6 July 2018

**RE: State Significant Development 8696
Lots 1, 2 & 3 DP 506925, Lot 122 DP 753238 & Lot 90 DP 657805,
No.909 Suntop Road, Suntop**

I refer to the Department's email dated 30 May 2018, inviting comments on the Development Application for the proposed solar farm located at the abovementioned property.

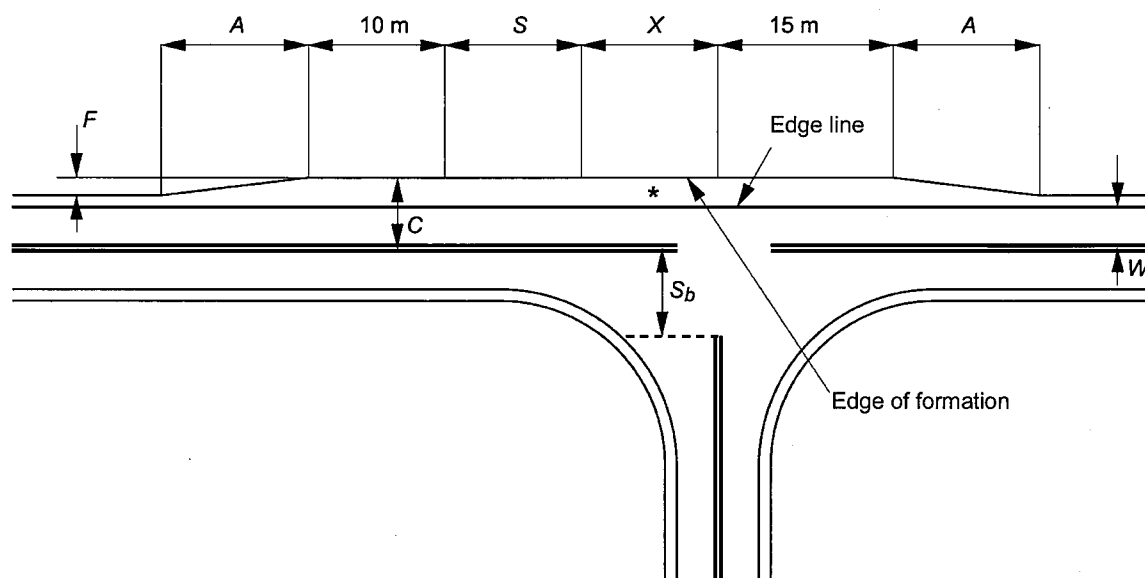
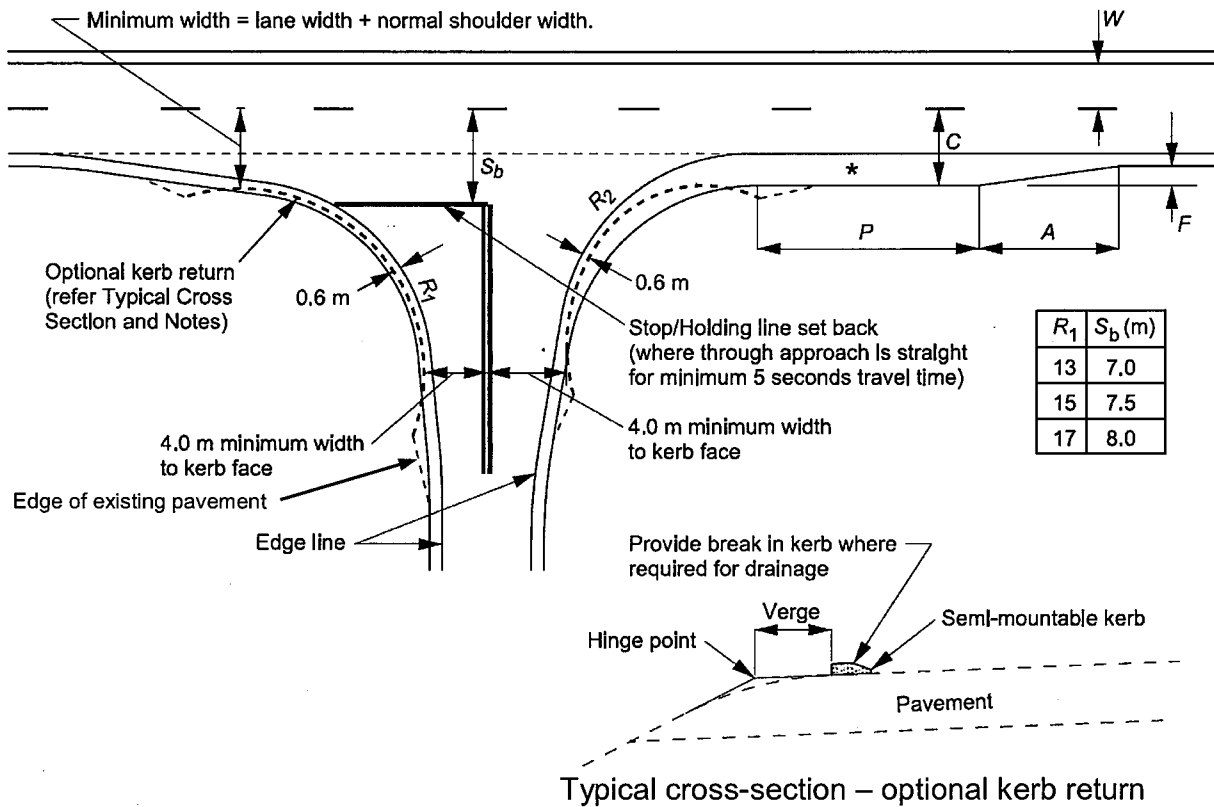
- A s138 application shall be made to Dubbo Regional Council for the construction of any permanent or temporary new access along Suntop Road;
 - Details of the permanent and temporary driveways shall be submitted to Council prior to any construction works, noting that the access driveways are to be designed and constructed of sufficient width at the roadway and the property boundary alignment such that a 'Semi-trailer' 19.0m in length (utilising the Austroads design templates, and a turning speed of 5-15 km/hr) is able to access the subject land in a forward motion from the through travel lane(s) of Suntop Road without the need to cross over onto the wrong side of the road at any time;
